**KIRKLEES METROPOLITAN COUNCIL
INVESTMENT & REGENERATION SERVICE**

Reference No: 2018/NM/93155/E

Site Address: 129, Oxford Road, Dewsbury, WF13 4EH

Description: Non material amendment to previous permission
2018/91736 for erection of first floor and two storey
side and rear extensions

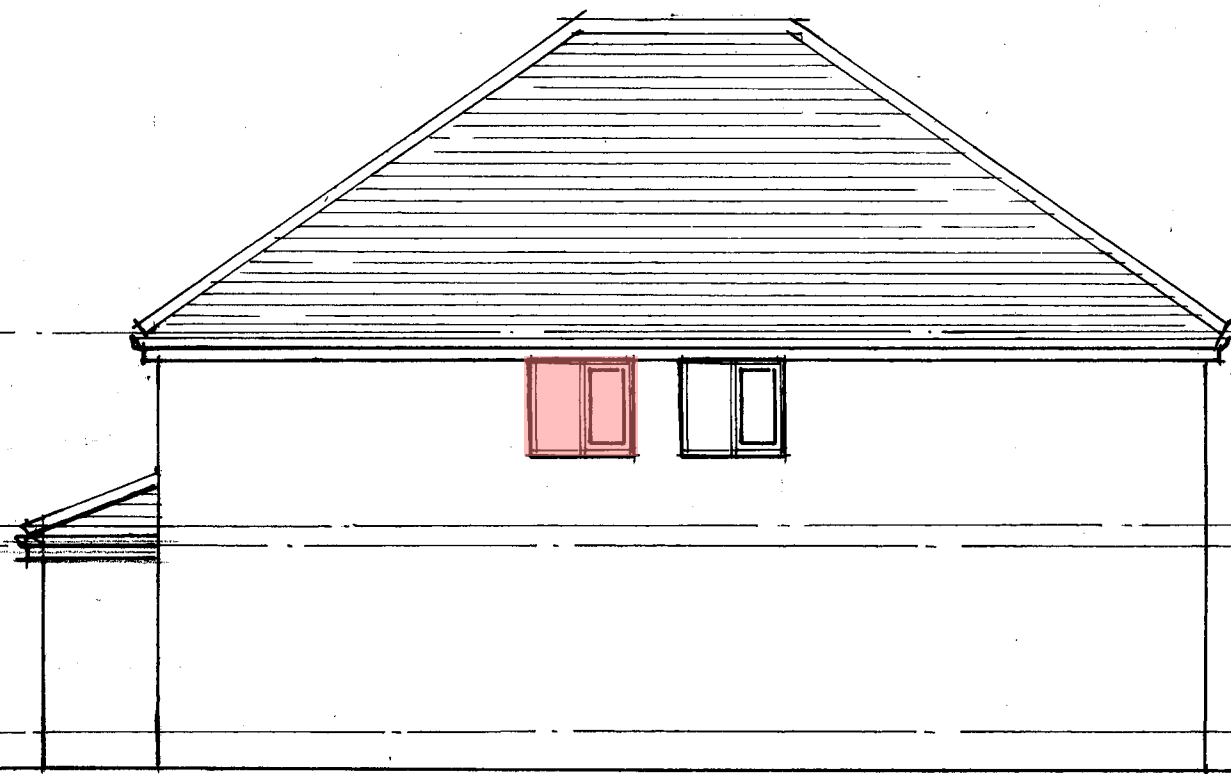
Insertion of a new first floor window serving an en-suite

The new opening is shown to be inserted in the side elevation of the approved first floor side extension. The property’s permitted development rights have not been removed for new openings and this can be reiterated in the officer’s original report, as it gives permission for a similar opening to serve a first floor bathroom.

An assessment has been undertaken to assess the impact the new non habitable window will have on residential amenity. In relation to overlooking/loss of privacy, the additional opening to the side elevation will not harm residential amenity of the neighbouring properties.

In accordance with section 2.5 of the councils NMA protocol, the insertion of a new opening to the first floor will not result in loss of privacy or amenity to the

neighbours. This is due to no.131 not having any existing openings in the adjacent elevation. Also as previously identified in this report and on the plans, there is an existing window serving a bathroom on the same side elevation of this property. In summary, the design of this window has already been assessed in relation to the existing window and as a result it will not alter the way in which the house is read.

Amendments have also been sought from the agent and applicant to remove the dining room window from the submitted plans due to the proposed window being within the elevation of the original house (refer to amended plans).
